Your Ref: OWPC26417
Our Ref: EP/37/20/HH 24-03-2020
Please ask for:
Zac Denton

Single storey side/rear extension, part two storey rear extension rear extension, raising of roof height to create a second floor and front double garage.

56 Angmering Lane East Preston Littlehampton

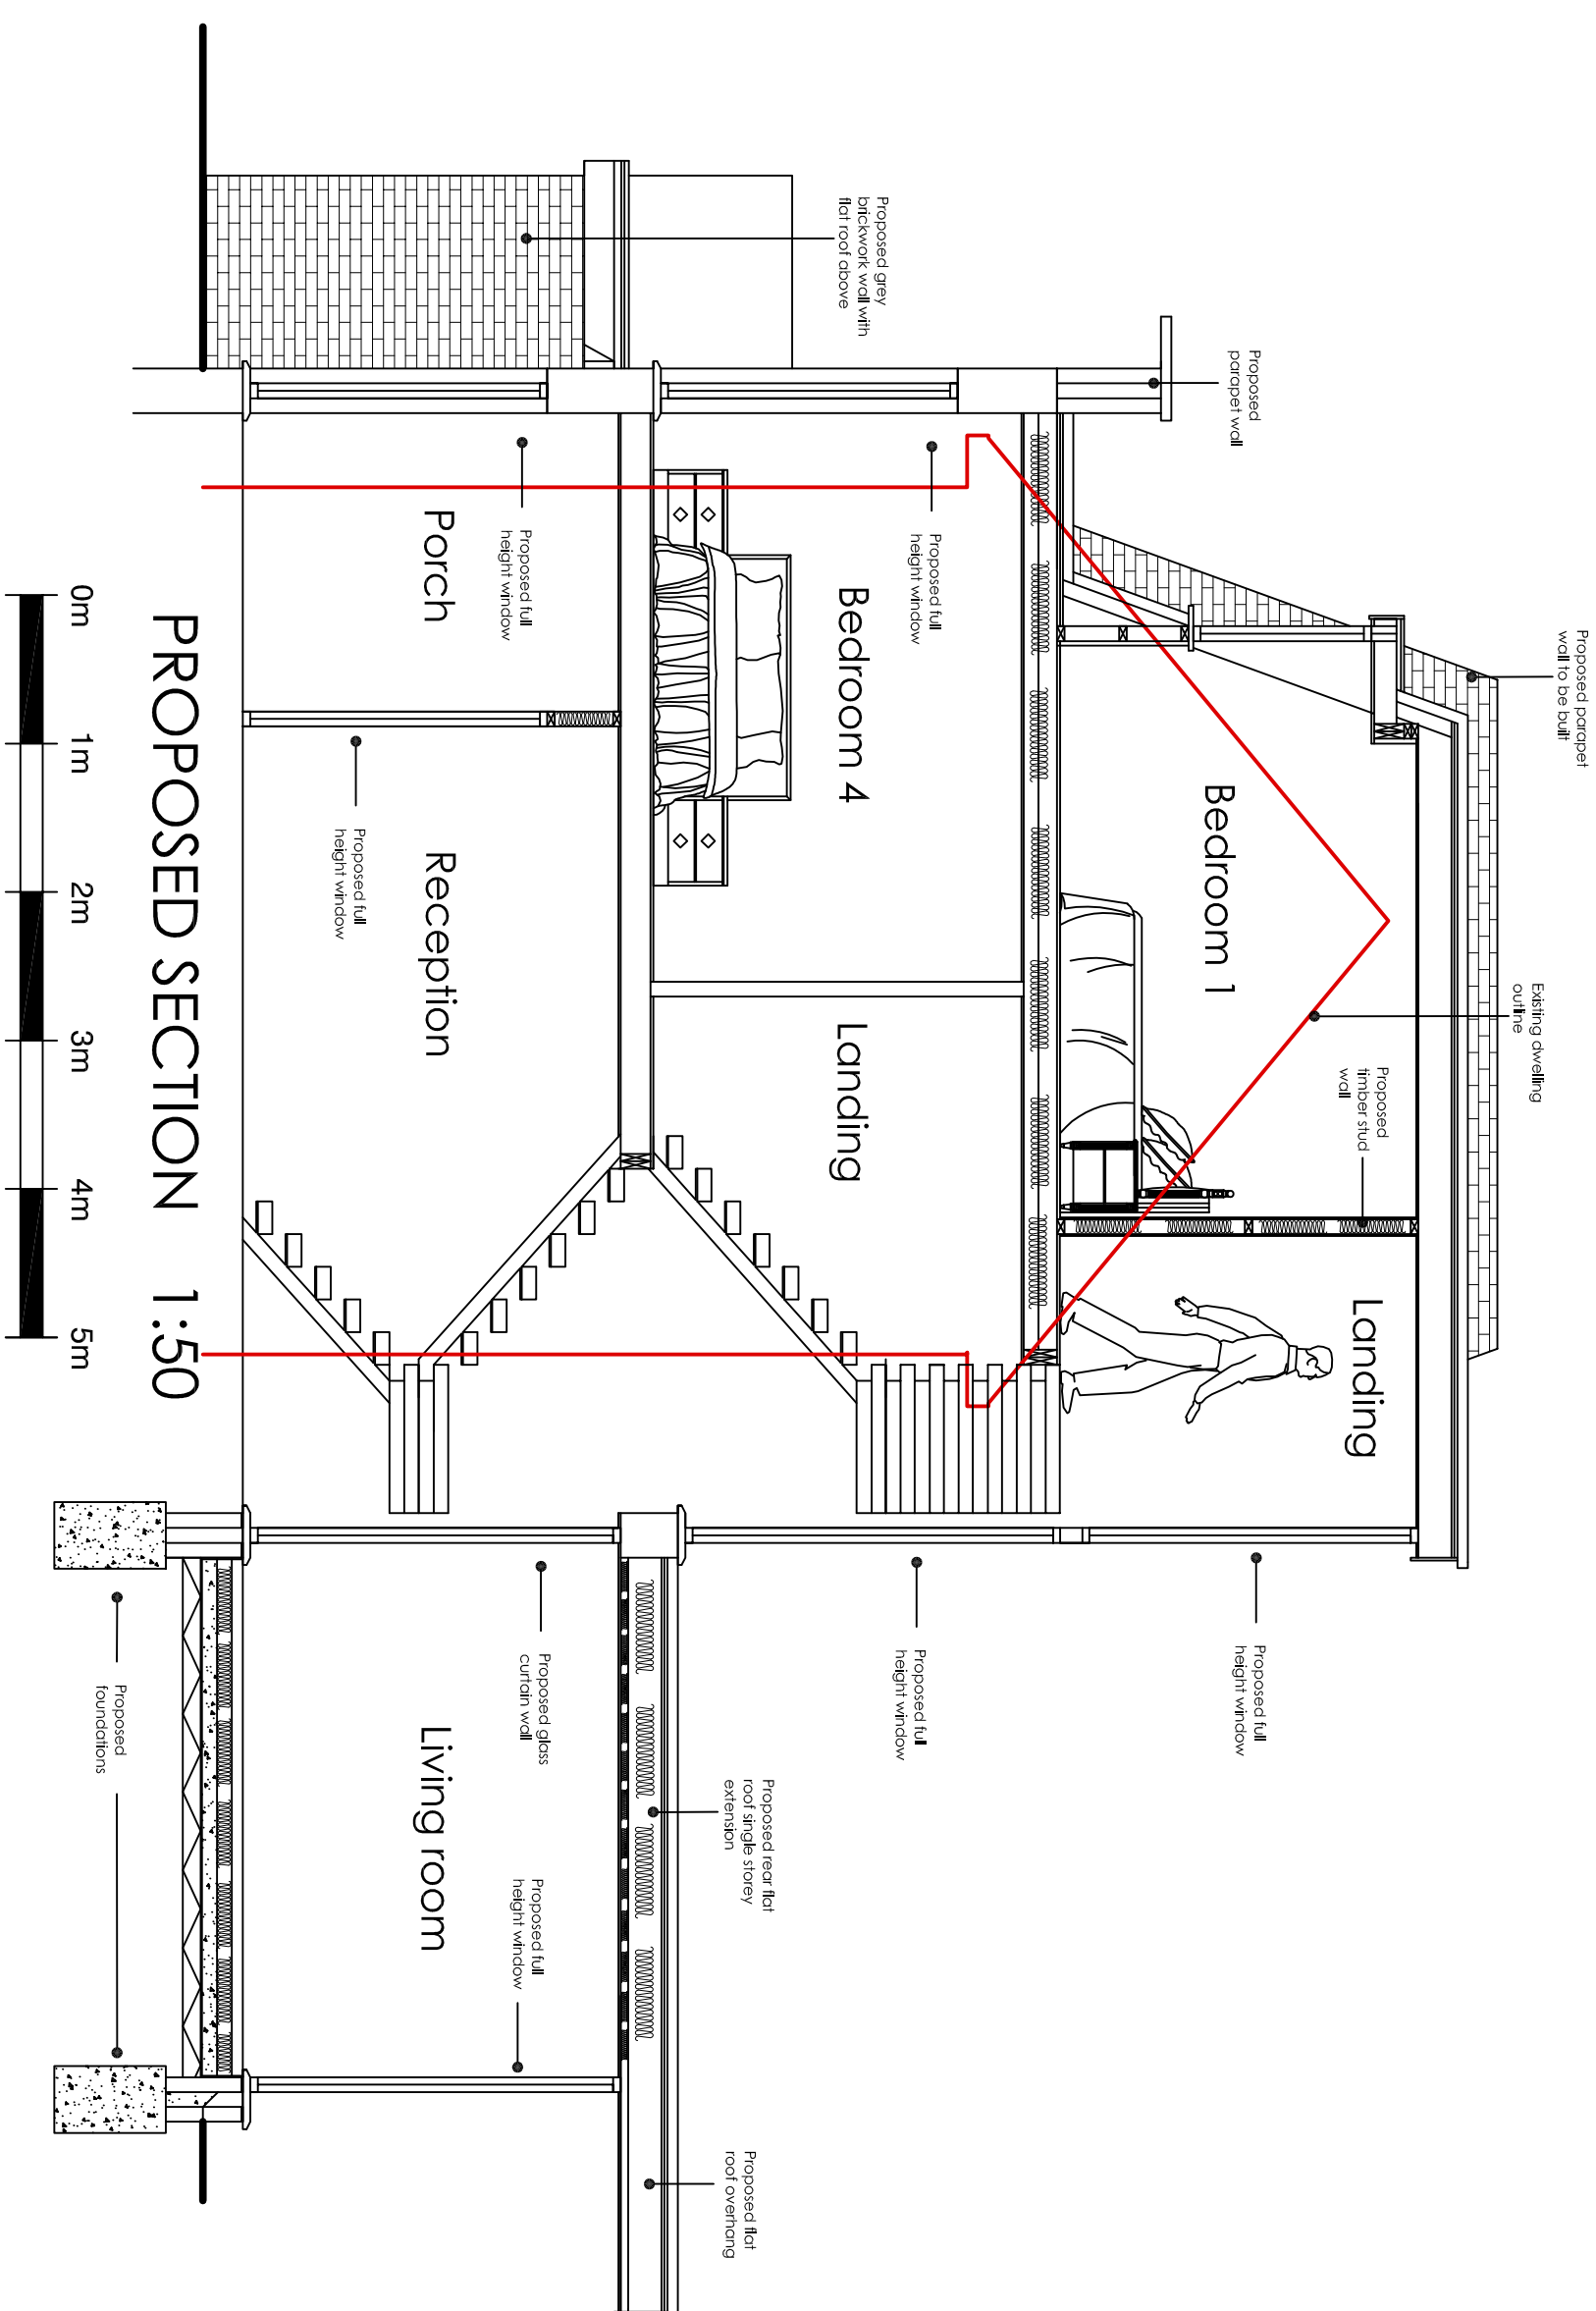
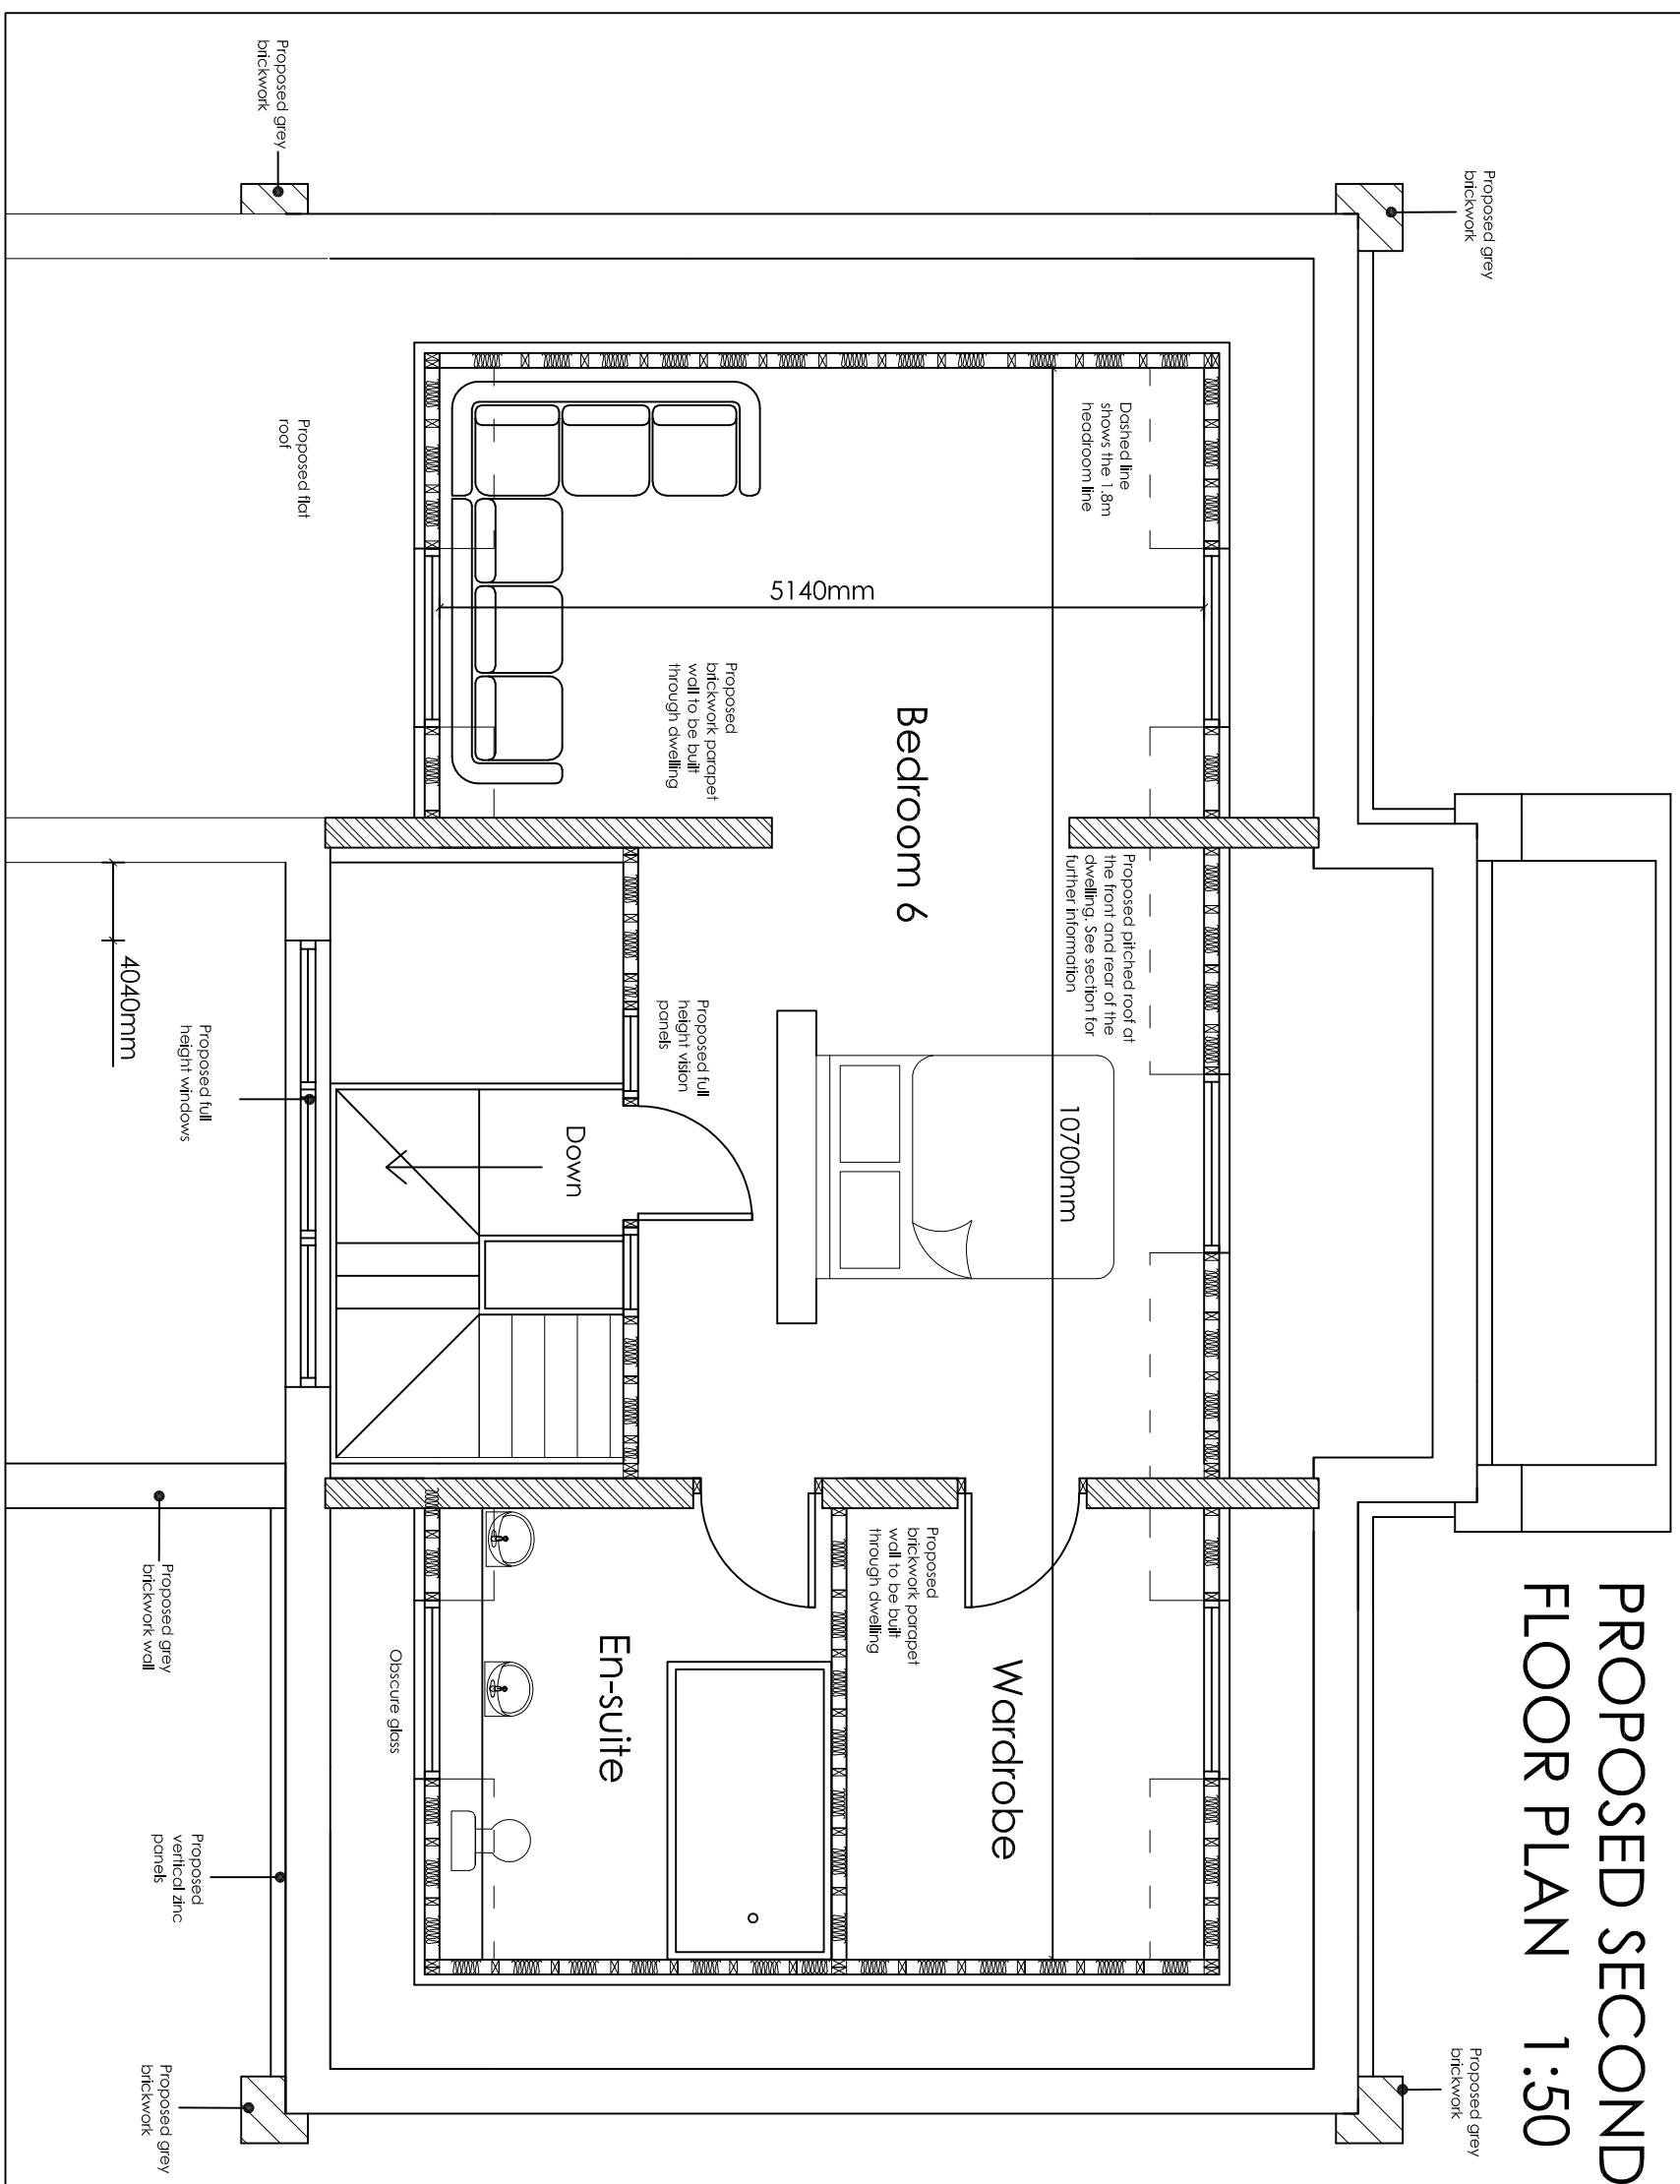
The proposal for a double garage to the front of the property is not acceptable as it is a clear breach of the 30 feet building line (from Angmering Lane) as recorded in the Charges Register for the property at the Land Registry.

The proposal to increase the height of the roof is not acceptable as it will have an adverse impact on the surrounding properties and the street scene.

The plans include the addition of a second storey to the property, with large vertical windows to the west (front) and east (rear) elevations.

This would result in a very unacceptable street scene, completely out of keeping with all other buildings in the surrounding area.

The resulting mass of the property, especially at second storey level, would be detrimental to neighbouring properties and the overall street scene.

The presence of second storey vertical windows would result in overlooking and privacy issues with neighbouring properties, both to the front and the rear.
